From: Biazar, Shahab
Sent: Friday, July 18, 2014 8:42 AM
To: 'Yolanda Padilla Moyer'
Cc: 'Grant Morrison (grant@inspectionsplusinc.com)'; Ortiz, Monica; Sims, Timothy E.
Subject: Bubba's Erosion & Sediment Control Plan, F17/E006A

I have the following comments on the submittal of the Bubba's Erosion & Sediment Control Plan, F17/E006A:

Standard Details

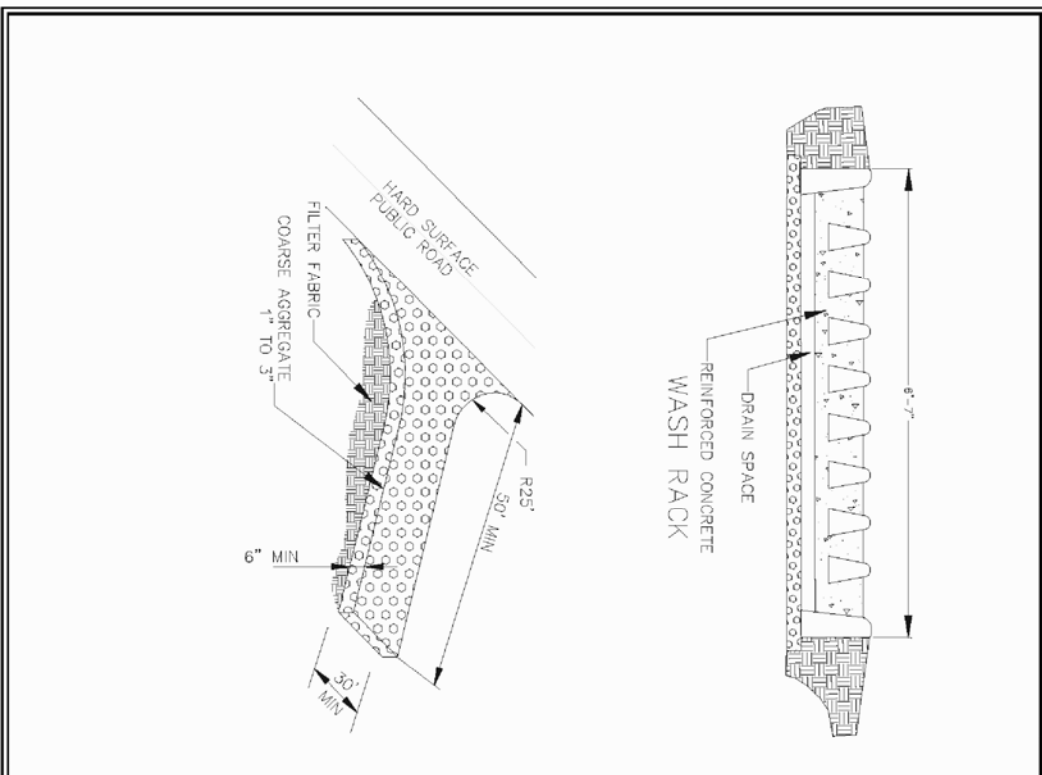
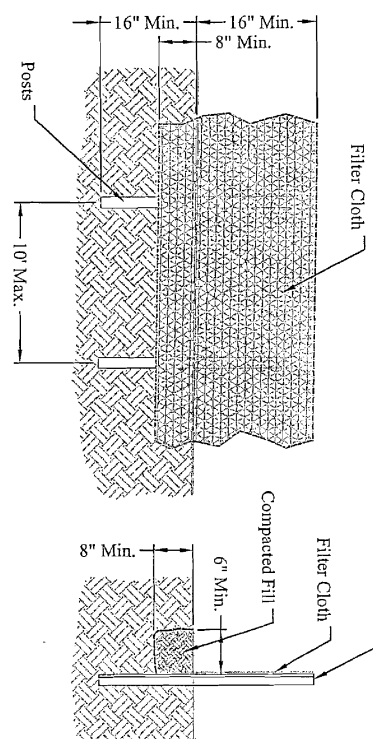
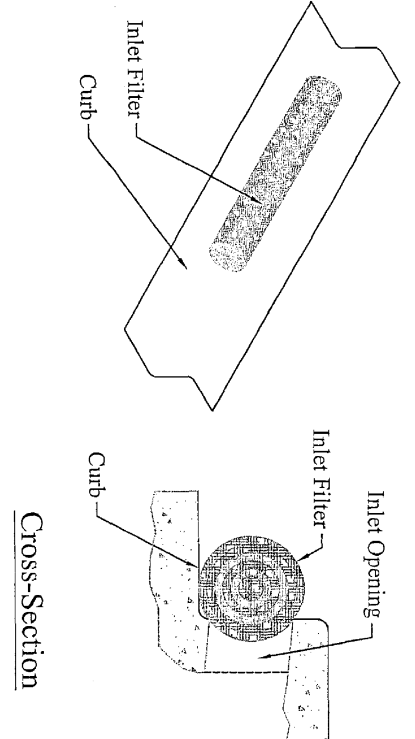
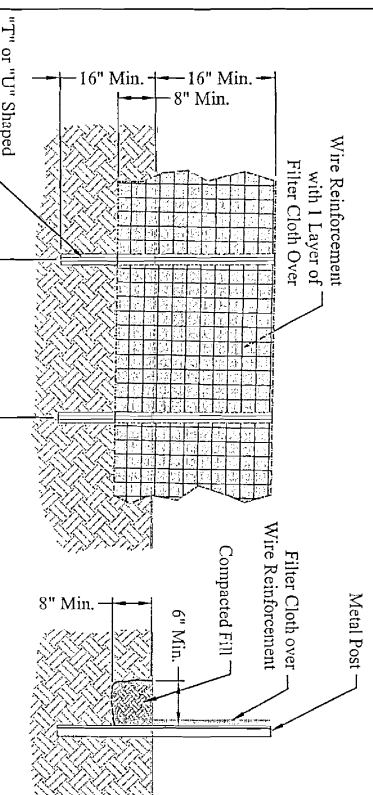
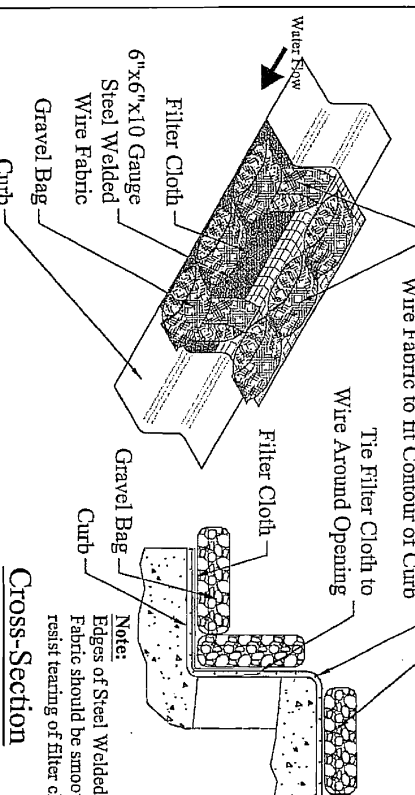
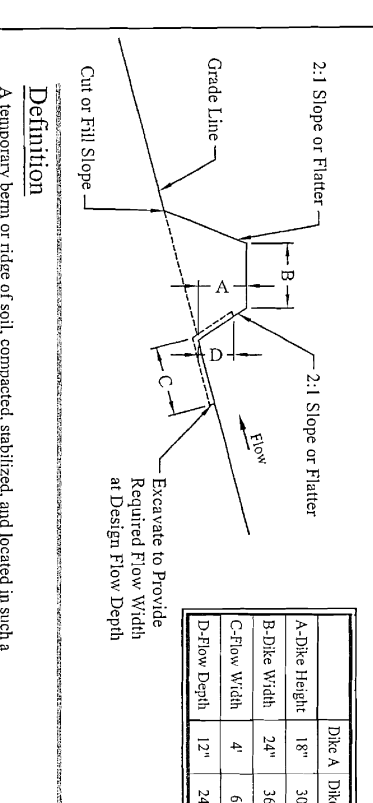
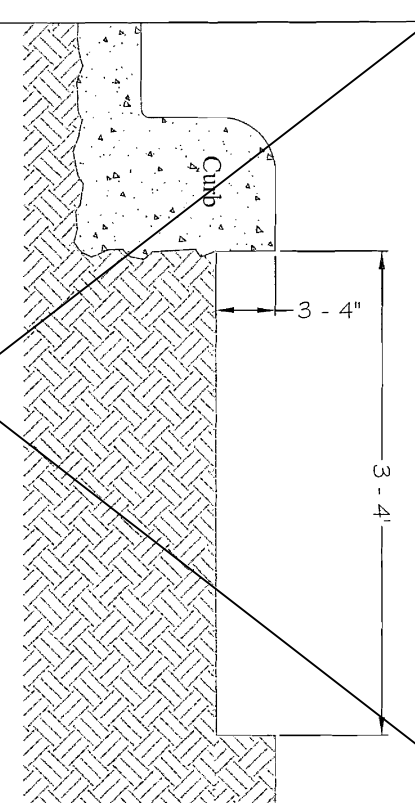
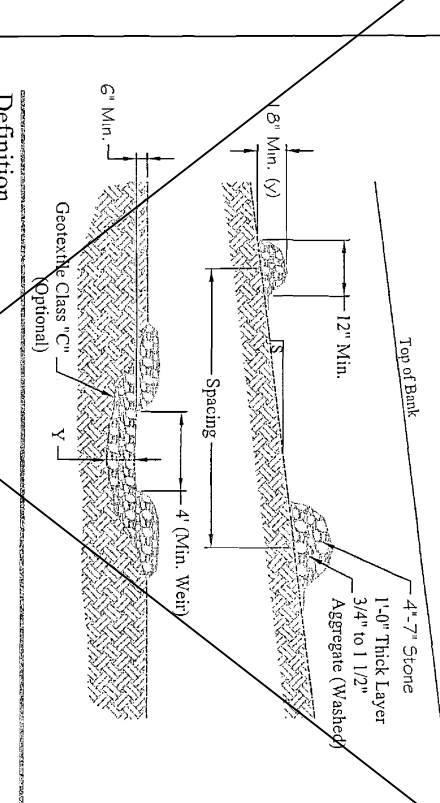
- _ Sing posting location should be shown on the plan (visible from public street)
- _ Provide a signed and stamped detail sheet.
- _ Should the silt fence be included around the work within NMDOT right-of-way work?
